From: Anita Gardner
Sent: 11 June 2020 16:47
To: [REDACTED]
Subject: EP/62/20/DOC - Gladwyn, The Street, East Preston

I have been allocated the above application and am carrying out the relevant consultations with other departments. However in the meantime I note that the information submitted with regard to discharge of conditions 8 -hard & soft landscaping and 10 - existing wall to south, lack sufficient detail at this stage. I will require confirmation of pot and plant sizes and plant numbers and details of replacement planting for the existing front border where the wall is being demolished and details of tree hedge retention and protection. For the walling the condition requires details

Scales: 1:50 1:200
No: 2386/01/12

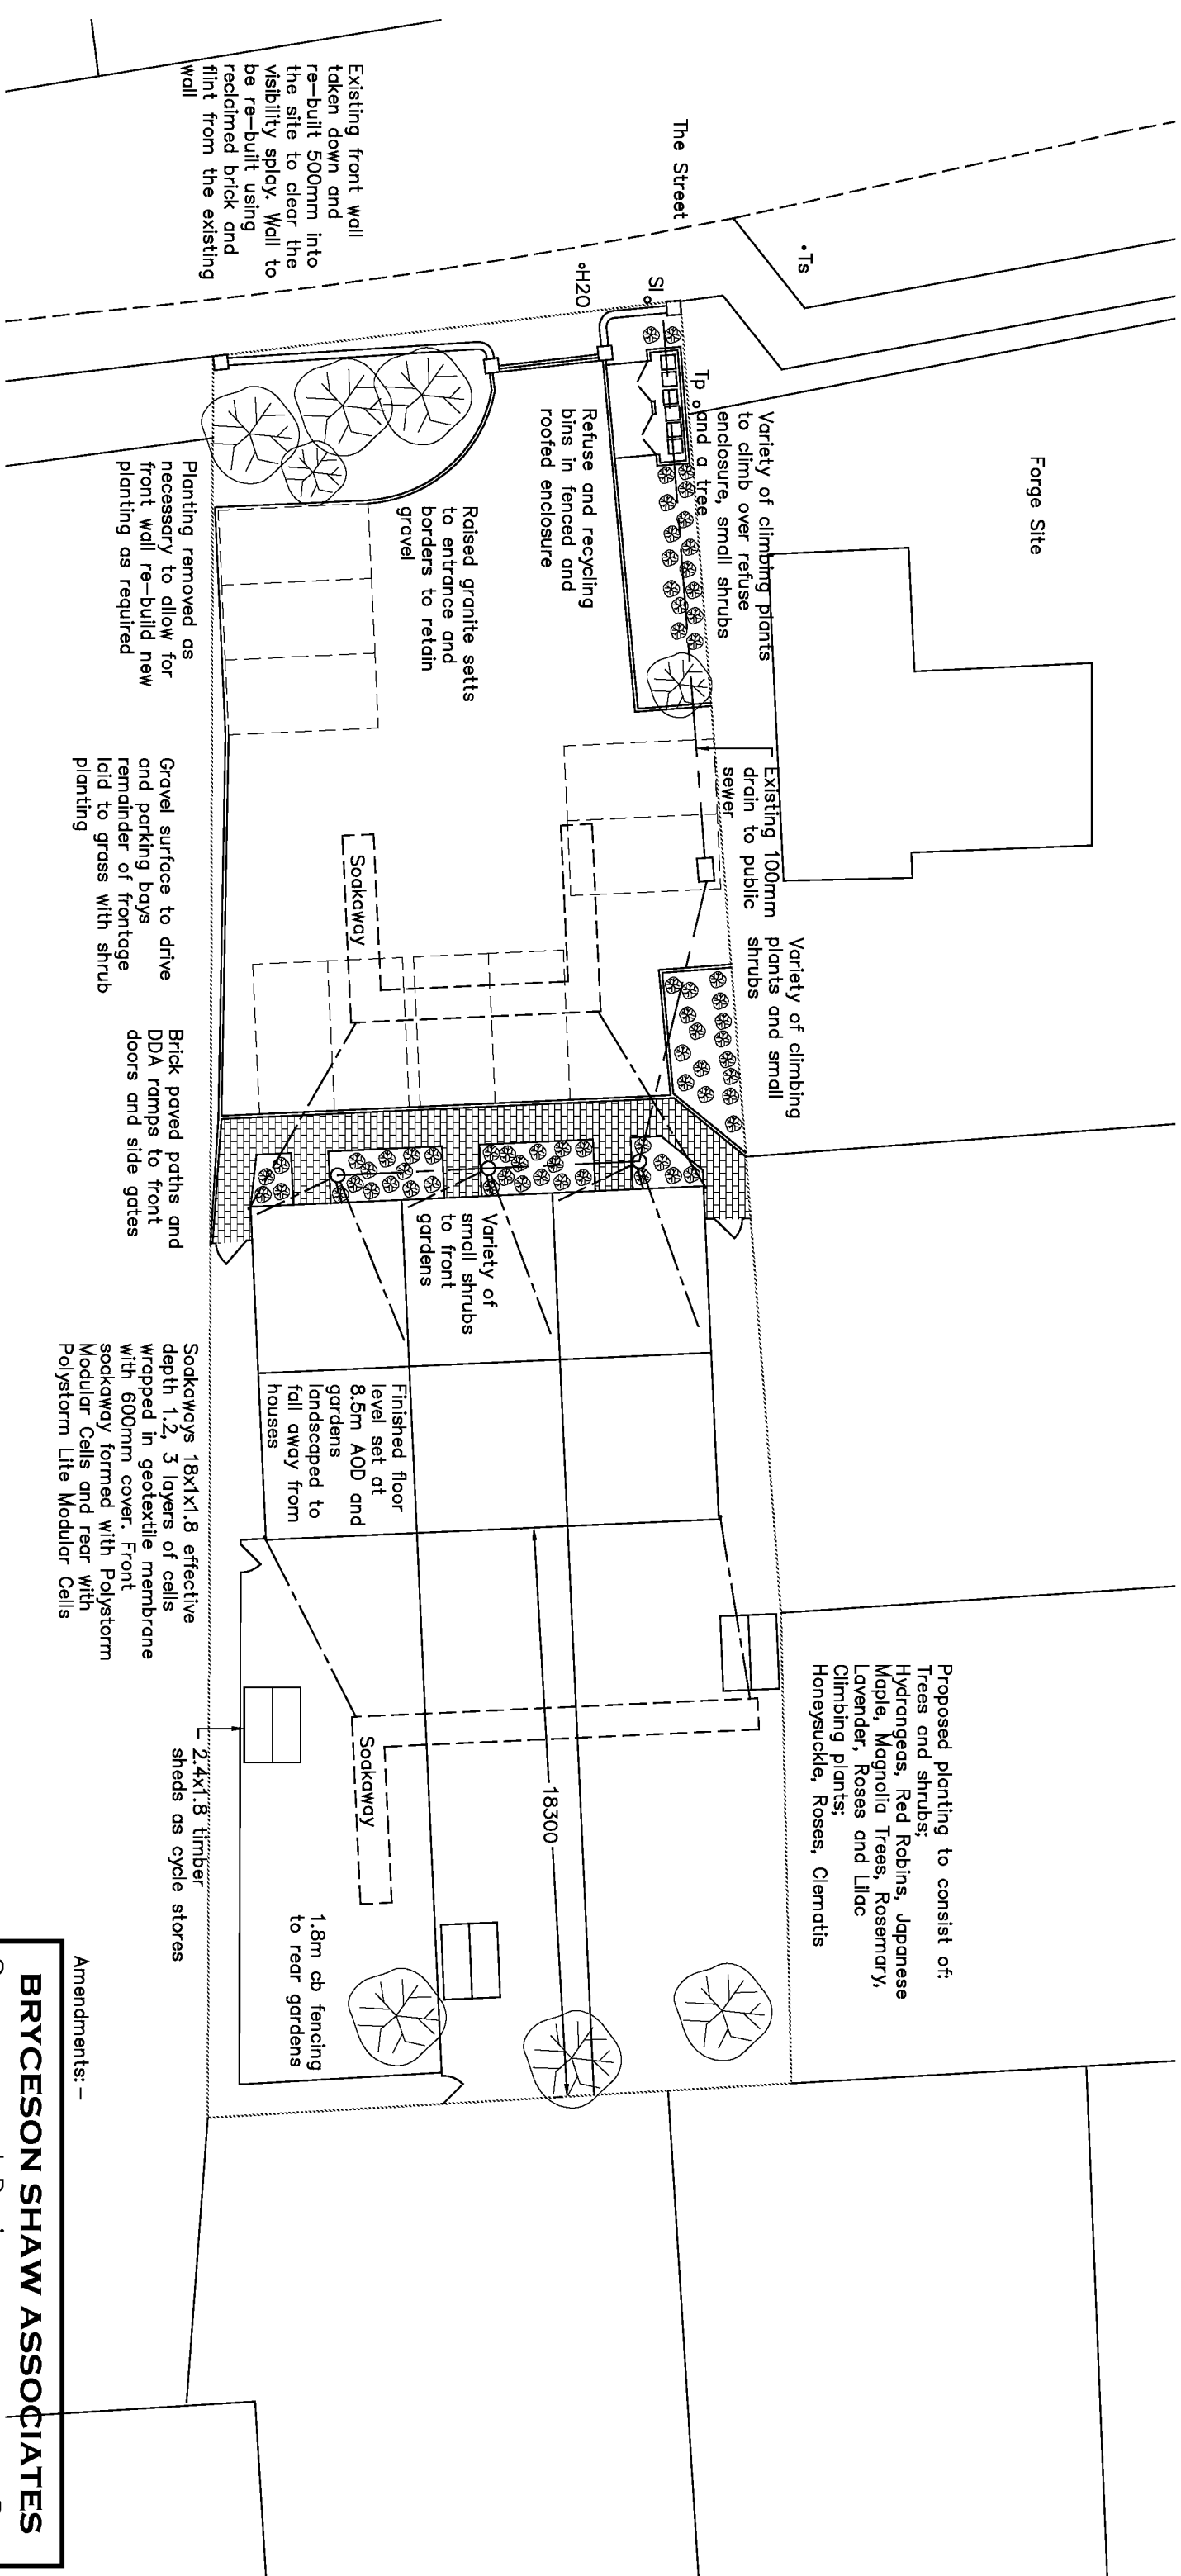
of method of demolition and rebuilding. I would suggest that photographs of the existing wall are provided as a reference point and that an elevation of the proposed replacement wall is provided to detail how existing bricks and flints will be reused together with the type of mortar and amount of protrusion of flintwork from cement.
